12409  
15 November 2013

**MODIFICATION TO APPROVED BOUTIQUE HOTEL (MP11\_0089)  
BLOCK 3A, CENTRAL PARK, CHIPPENDALE**

On behalf of Sonrac Developments Pty Ltd, we write to request that the Minister (or his delegate) modify Project Approval MP 11\_0089 under section 75W of the *Environmental Planning and Assessment Act 1979* as described below.

1 WEST ELEVATION
1:100

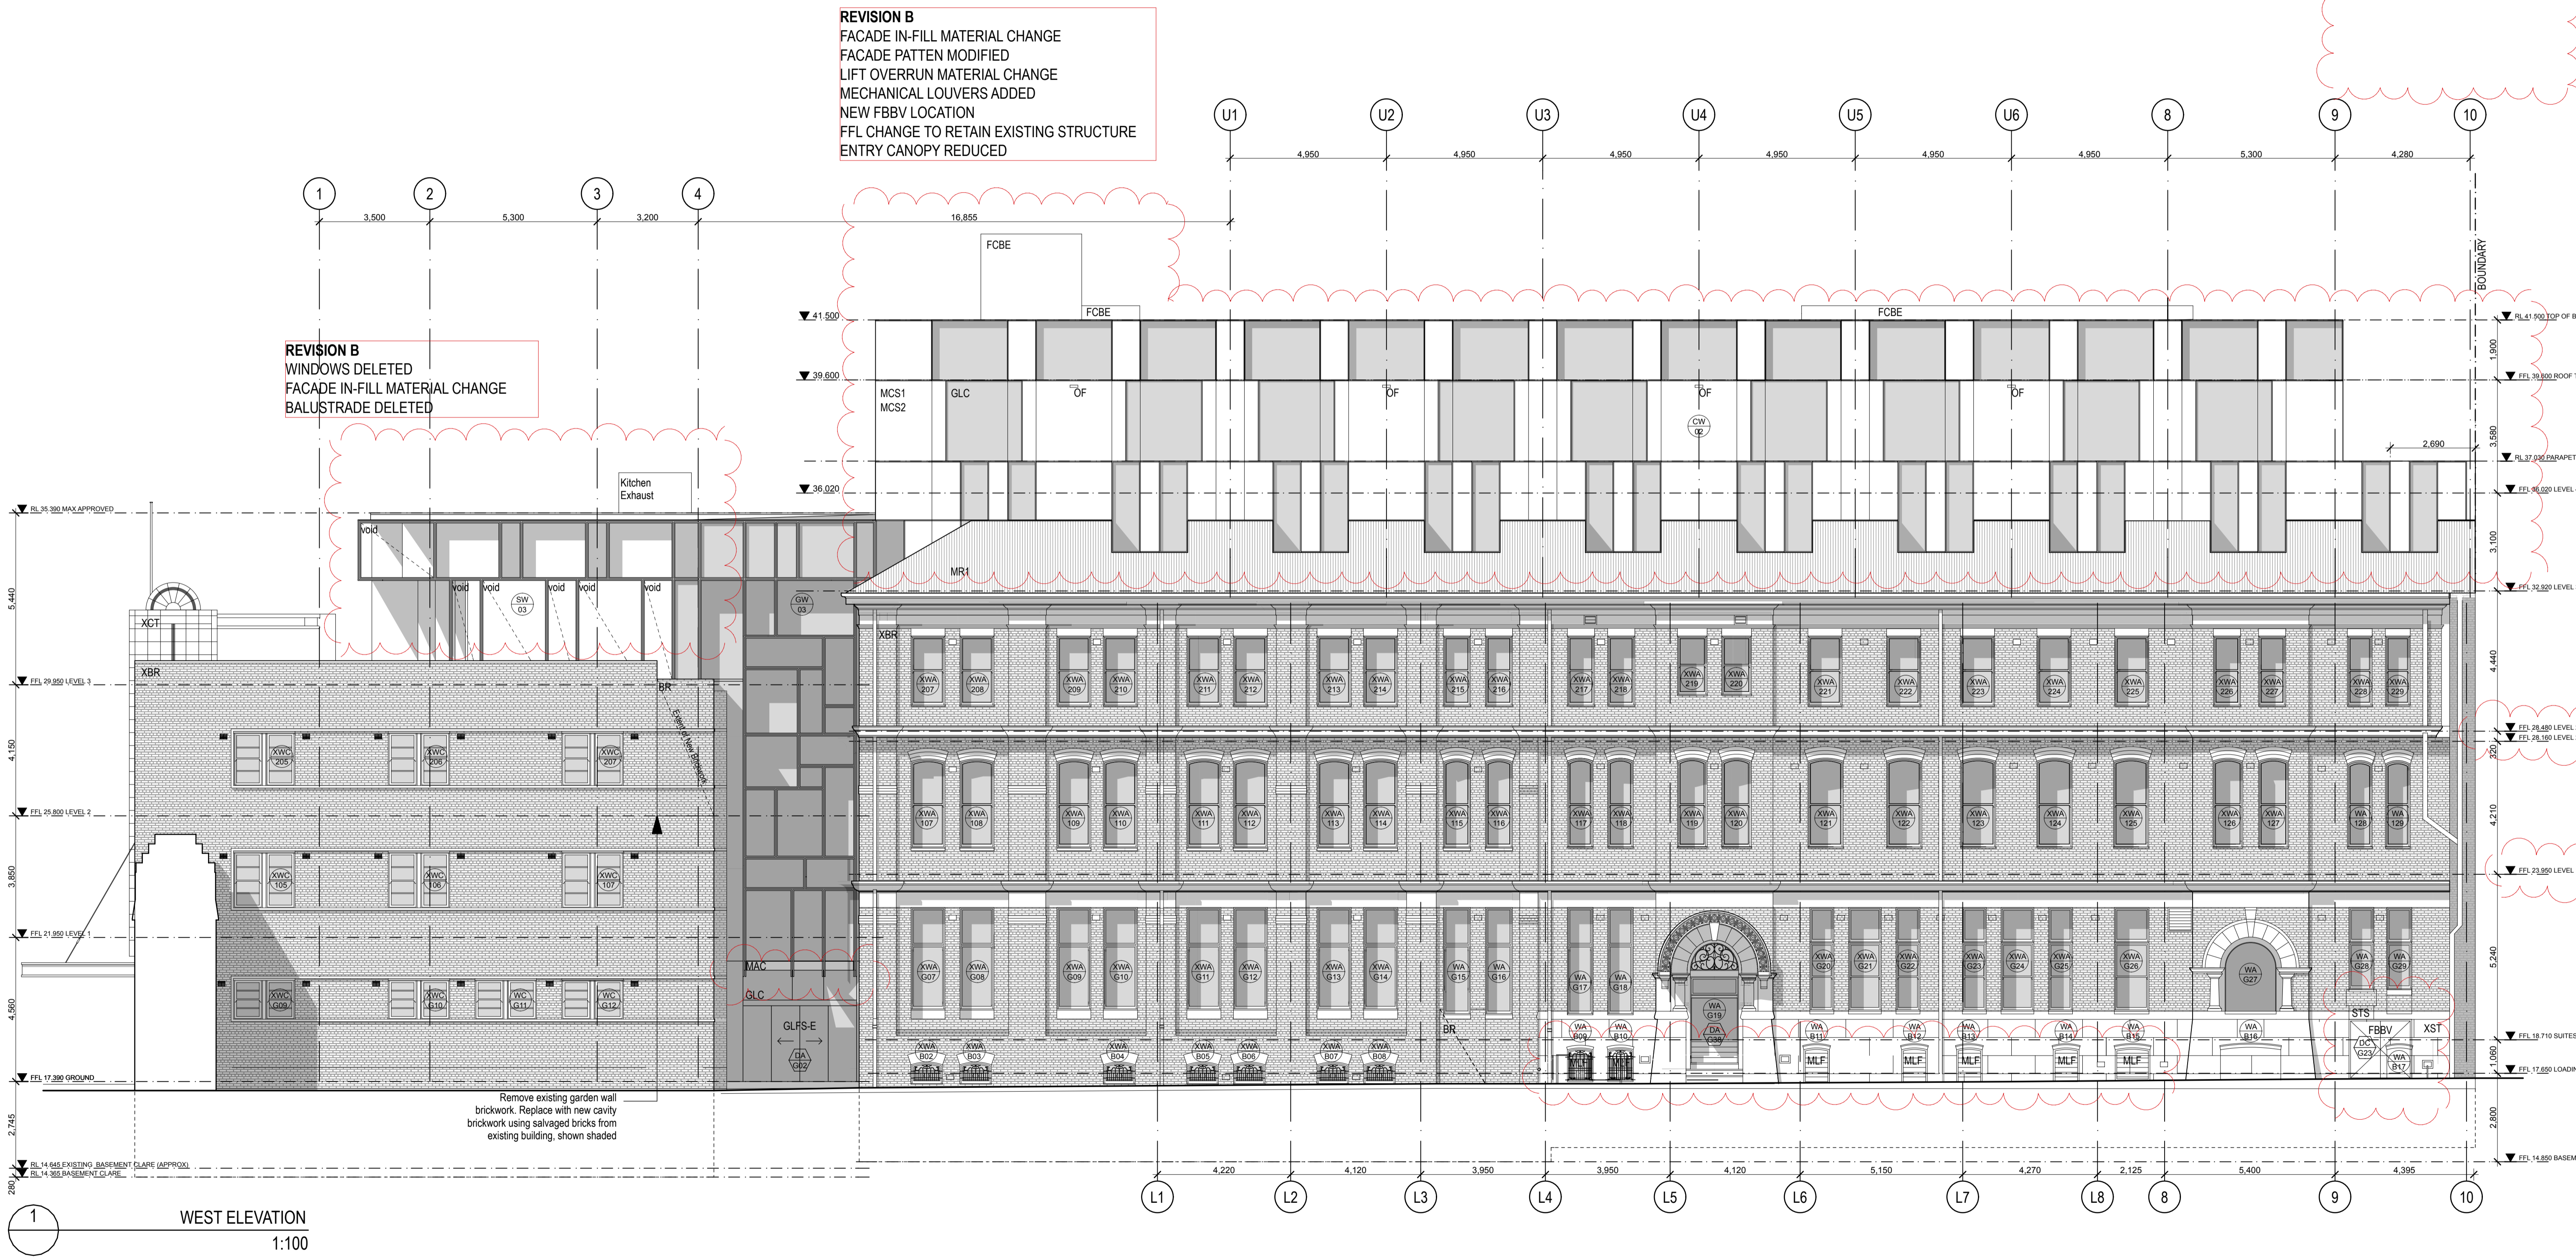
The eastern façade has been modified by the change to the loading bay door which is now a swing door, and the western façade has been modified by the relocation of the FBBV from the northern façade to the bottom right of the western façade. The western façade is also modified by the reduced size of the entry canopy at level 3.

REVISION B
FACADE IN-FILL MATERIAL CHANGE
LIFT OVERRUN MATERIAL CHANGE

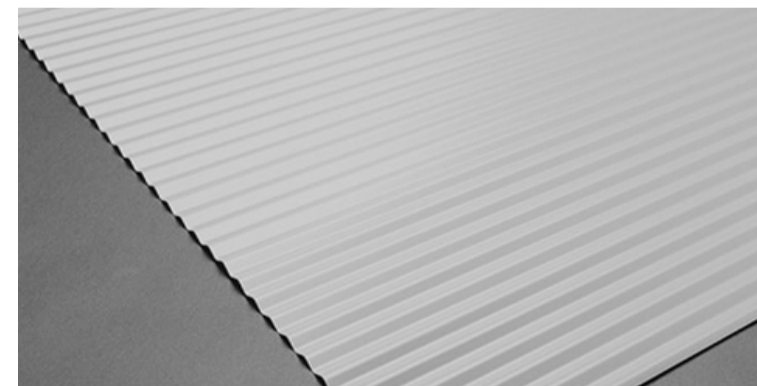
On the façade, the infill panel and lift overrun materials have been amended, as has the overall pattern which now presents as more formalised.

As a result of detailed design development the façade patterning has been formalised and the infill panel material has been modified. However, the façade design and selected material retains the overall aesthetic of the built form.
